**CITY OF PORTLAND, MAINE**  
**HISTORIC PRESERVATION BOARD**

February 27, 2013

Re: Renovation of Existing Rear Addition; 143 Spring Street

Proposed Shed
Elevations and
Section

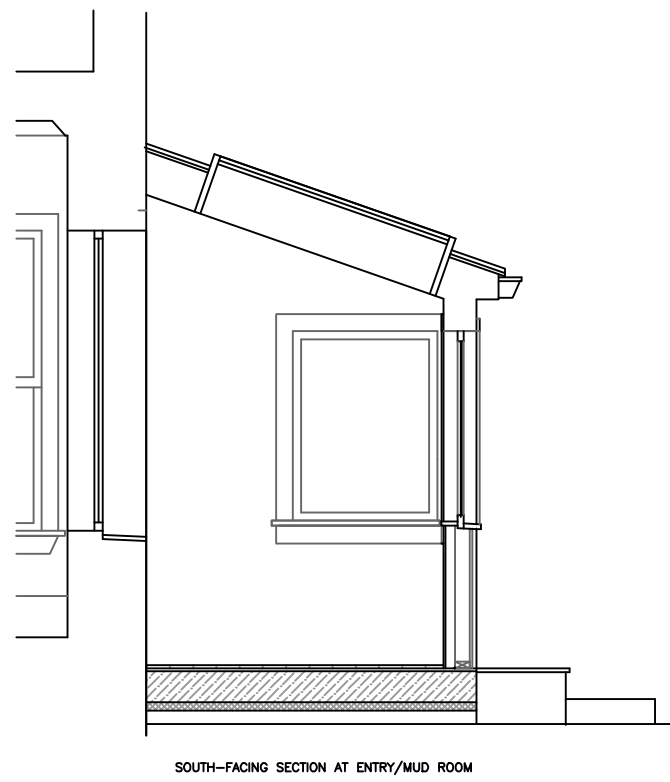
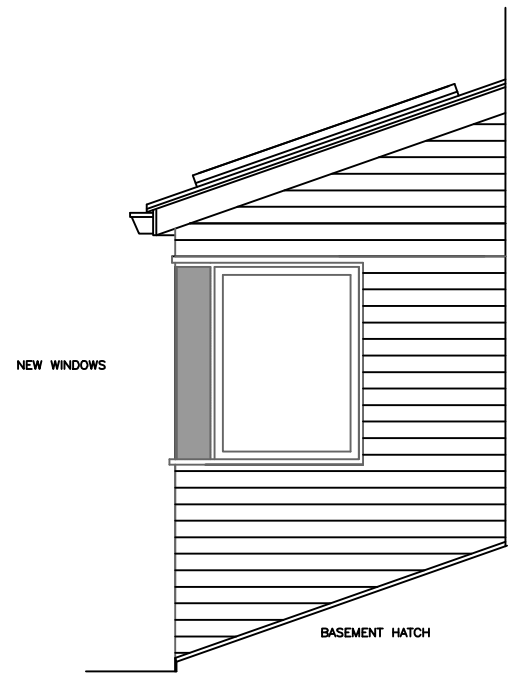
This office has reviewed and approved your proposal, submitted on behalf of clients Sam and Bethany Mateosian, for exterior alterations to an existing rear addition at 143 Spring Street. Alterations include the addition of four skylights and replacement of the existing door and windows, as depicted in your elevations dated 2/1/2013.

- \* All exterior elements--including siding, trim, window and skylight frames --to be finished in a dark, monochromatic color scheme.
